FG/172/17/HH

Re: Proposed Development

5 SARK GARDENS, FERRING.

PROPOSED ELEVATIONS 1:100@A3

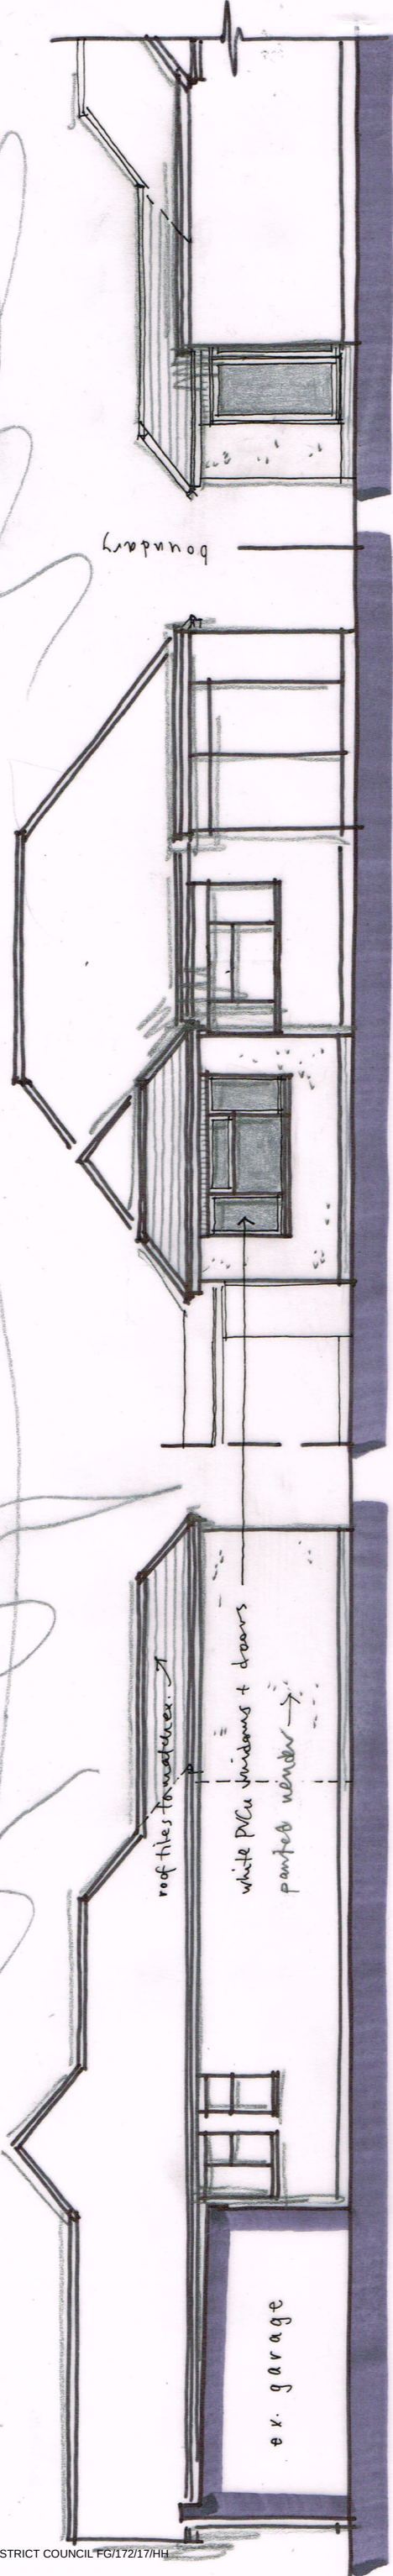
On the planning application the description of the material is described as render & was started in mid October. This is now completed & is not in keeping with the rest of the properties in Sark Gardens which is brick.

GROUND FLOOR PLAN 1:50

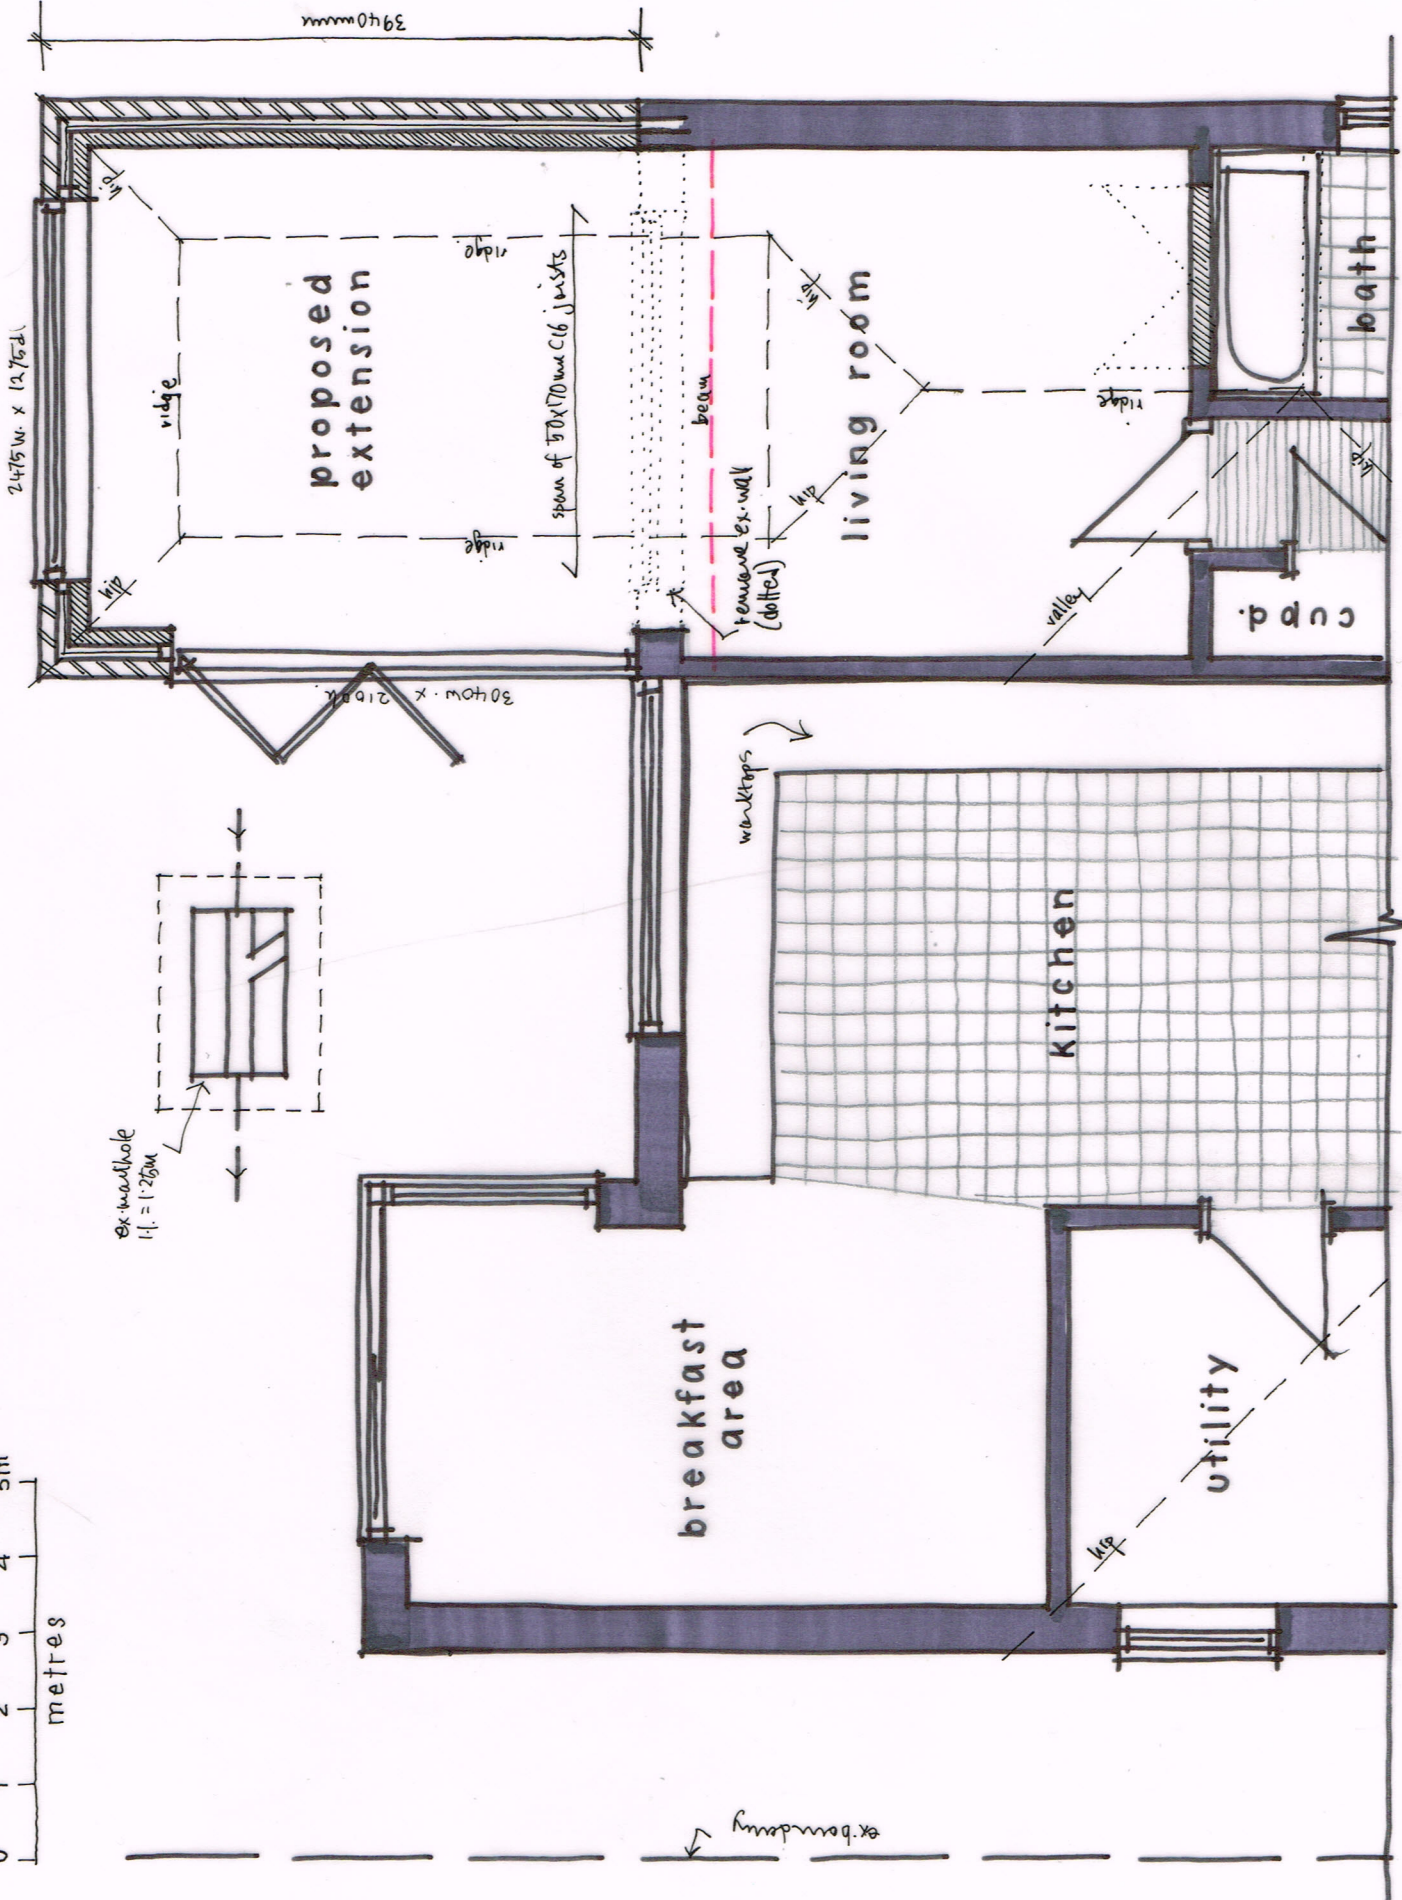
The plans also show the extension which has also been completed & extends 3.9 meters.

Neither the existing or proposed plans show any bedrooms or any alteration to the loft space or for any windows.
